# **A46 Newark Bypass**

**Scheme Number: TR010065**

## **Statement of Common Ground with Newark and Sherwood District Council 'NSDC'**

**Statement of Common Ground with  
Newark And Sherwood District Council**

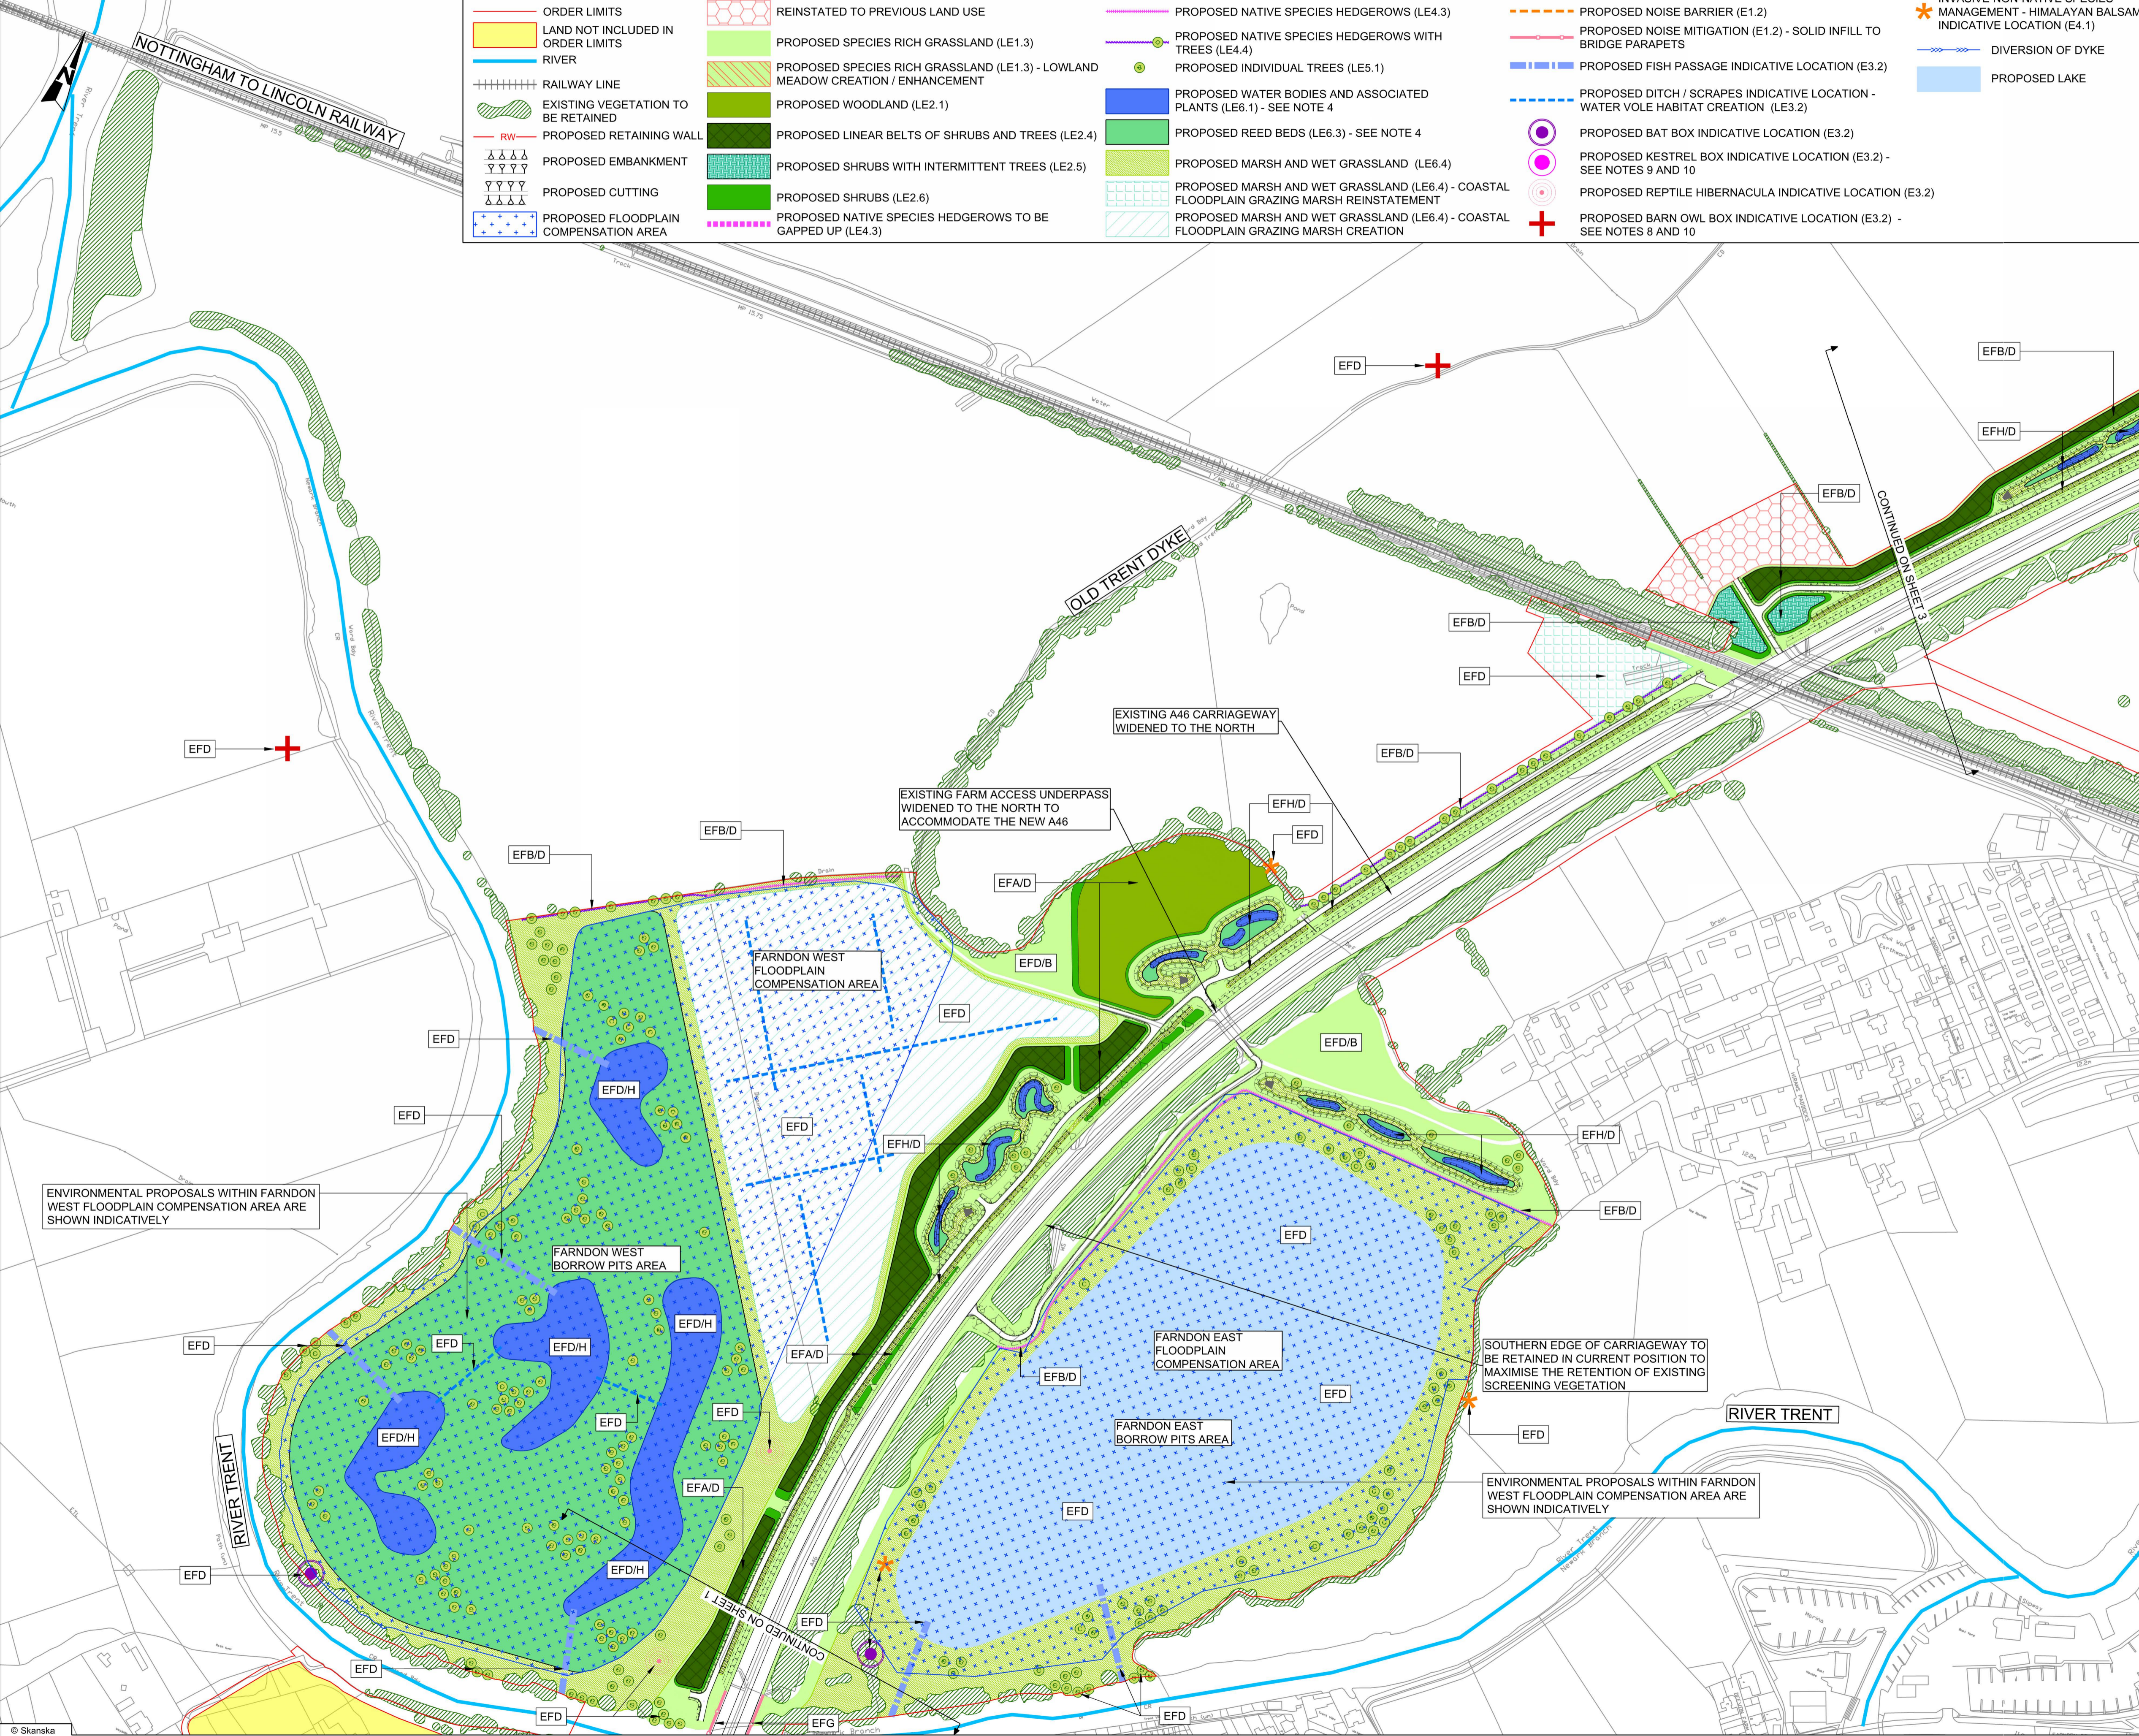
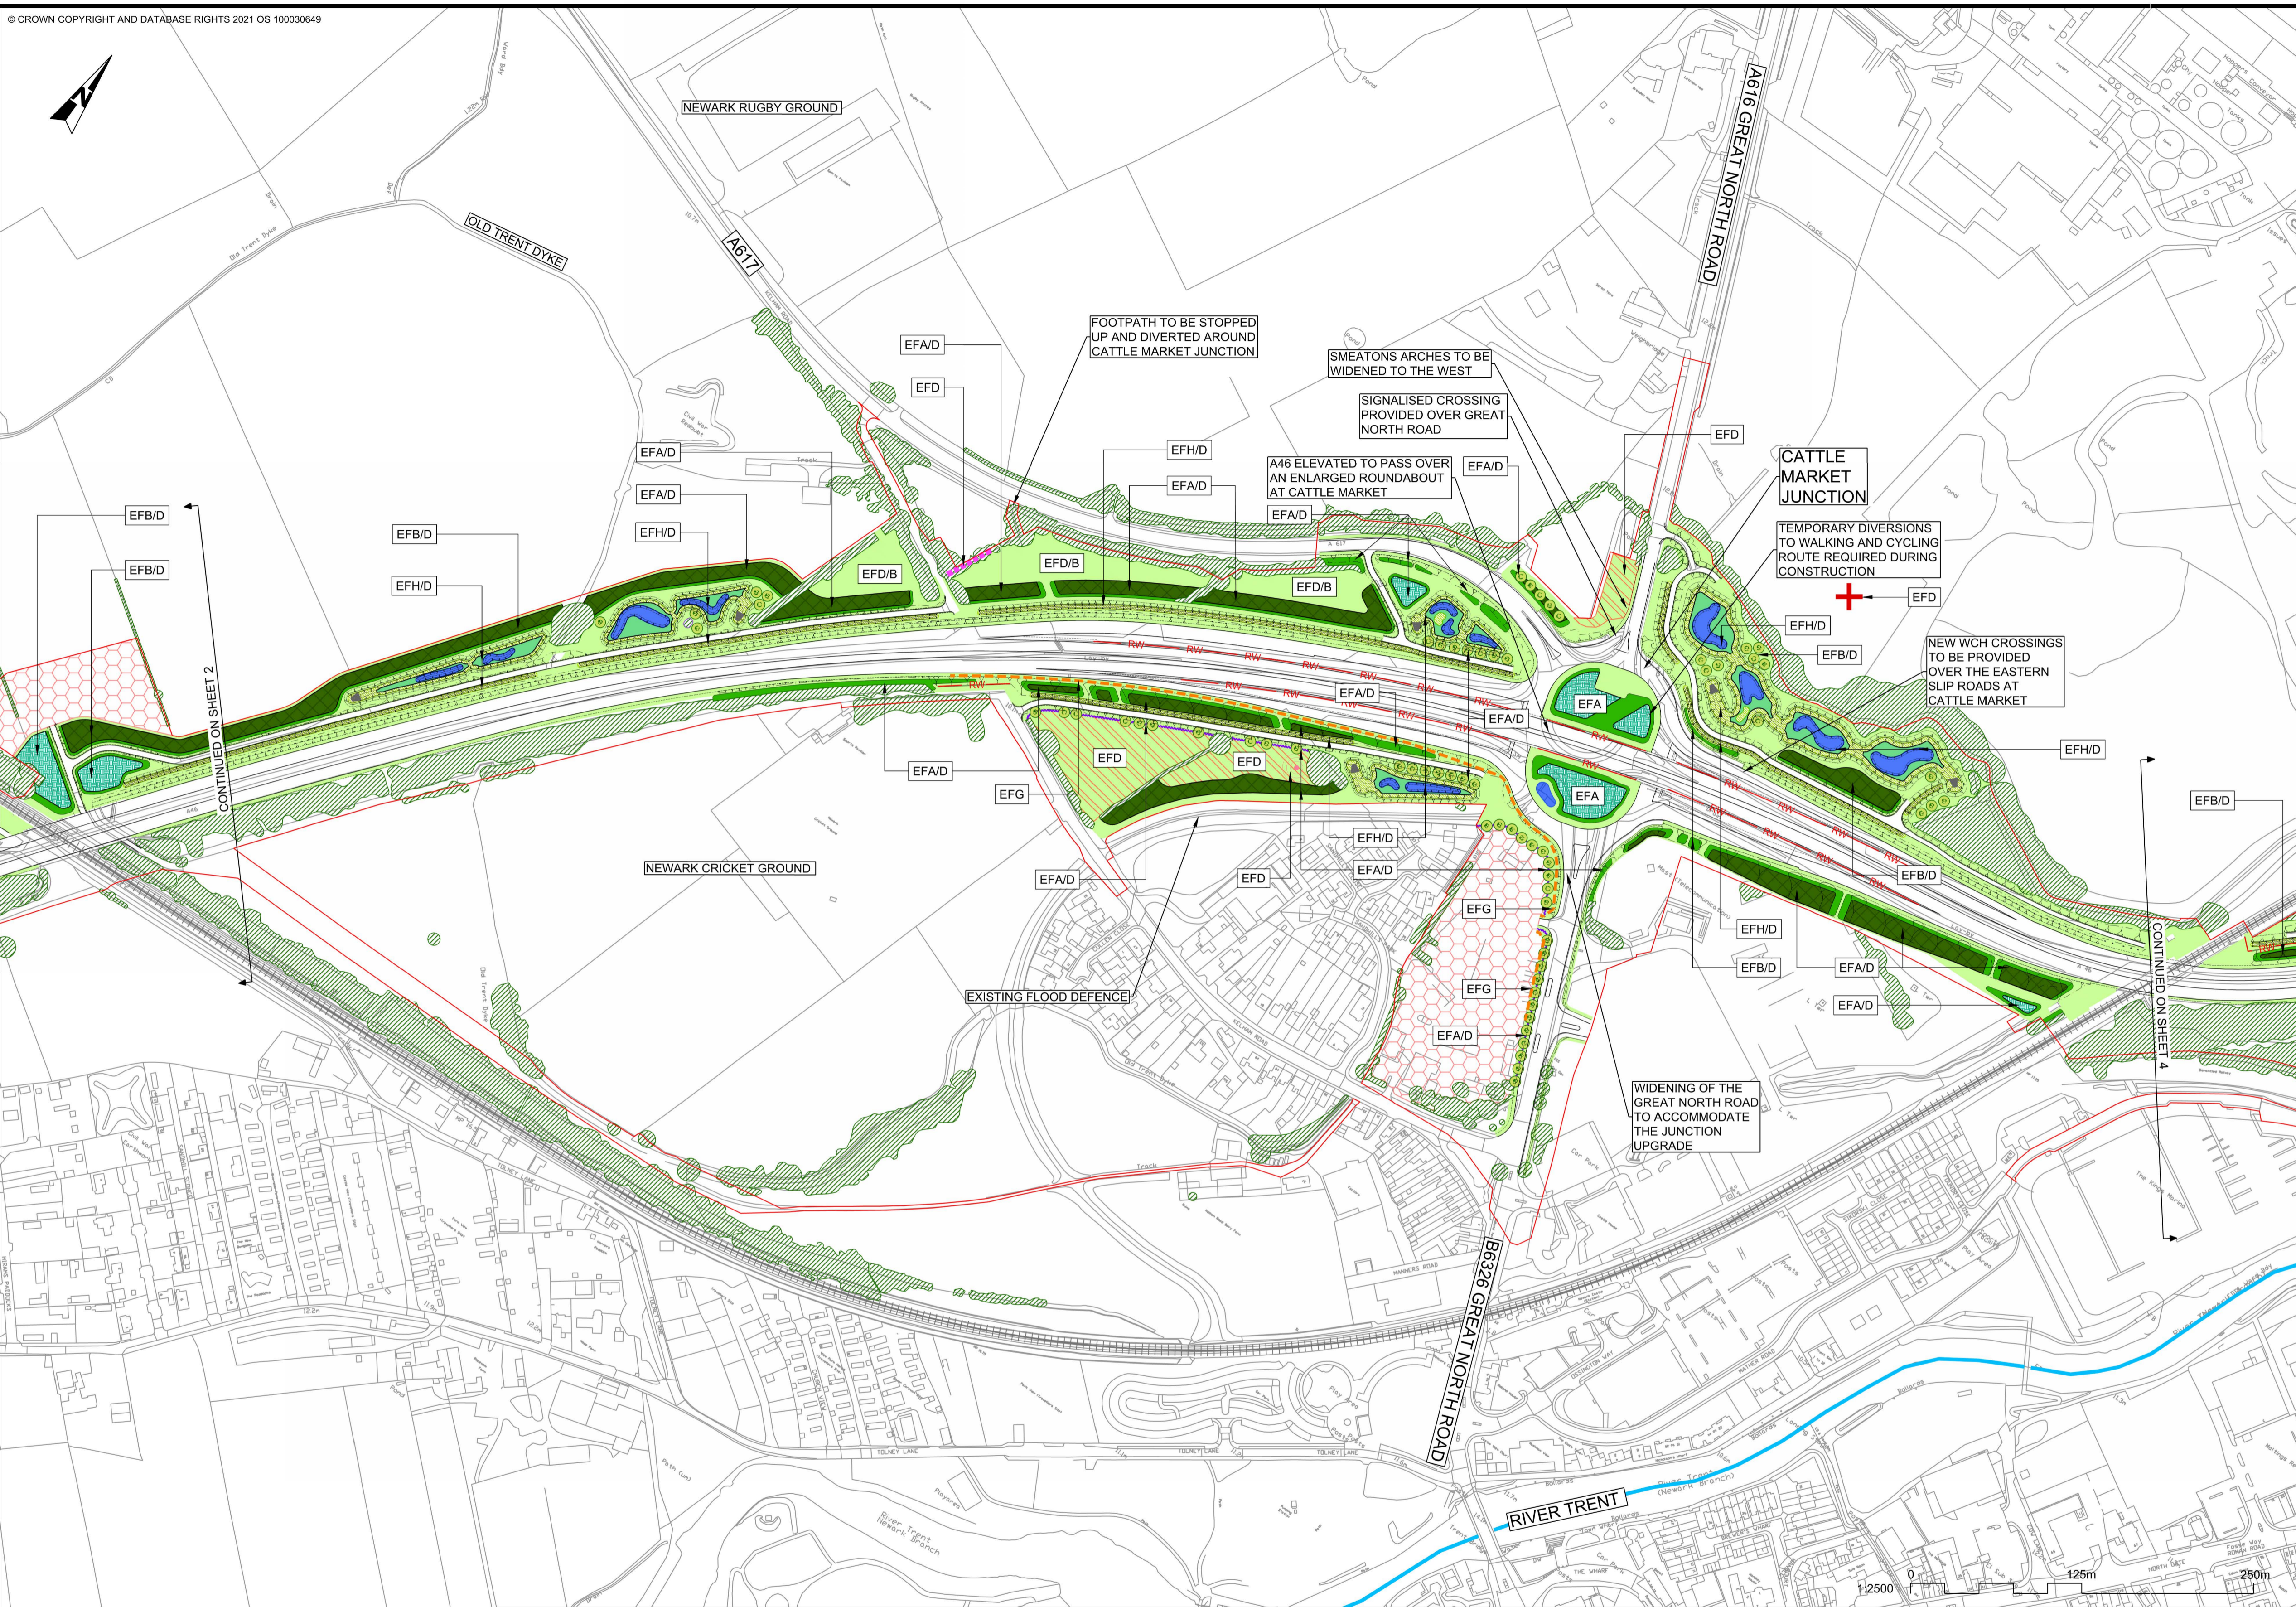
Issue No.	Issue	Document Reference	Newark and Sherwood District Council's Position	The Applicants Position	Status	Date status confirmed
12.	Design (including justification for any flexibility being sought)	Chapter 2 The Scheme of the Environmental Statement [APP-046] 6.2 Environmental Statement - Figure 2.3 Environmental Masterplan [AS-026]	<b>Cattle Market flyover</b> On the fly-through video the structure of the elevated over-pass at the Cattle Market junction appears as a stark and imposing concrete structure. This may be in part due to the animation which depicts it as being very bright in colour and therefore standing out vividly. The Council would want to understand proposals to ensure the visible impact of the final structure is minimised and/or mitigated as far as practicable.	Consideration has been given to the aesthetic finish of the structure during the design development to help to reduce the visual prominence of the structure and to reflect finishes on existing structures such as that of Smeaton's Arches just to the north of the new junction. Further details of these can be found within Chapter 2 The Scheme of the Environmental Statement [APP-046] and 6.2 Environmental Statement - Figure 2.3 Environmental Masterplan [AS-026]. Planting of trees and shrubs has also been considered and incorporated wherever feasible to help break up the visual mass of the structure, with planting softening the built form and aiding screening over time, particularly from properties such as those in Sandhills Park affording near distance views. The assessment of landscape and visual effects and associated design and mitigation measures are described in 6.2 Environmental Statement - Figure 2.3 Environmental Masterplan [AS-026] and presented in 6.2 Environmental Statement - Figure 2.3 Environmental Masterplan [APP-026]. Part of the Detailed Design process will be to define the finish of the retaining walls forming the Cattle Market Flyover. This will be a masonry type façade and not a bare concrete finish.	Under Discussion	16/10/2024
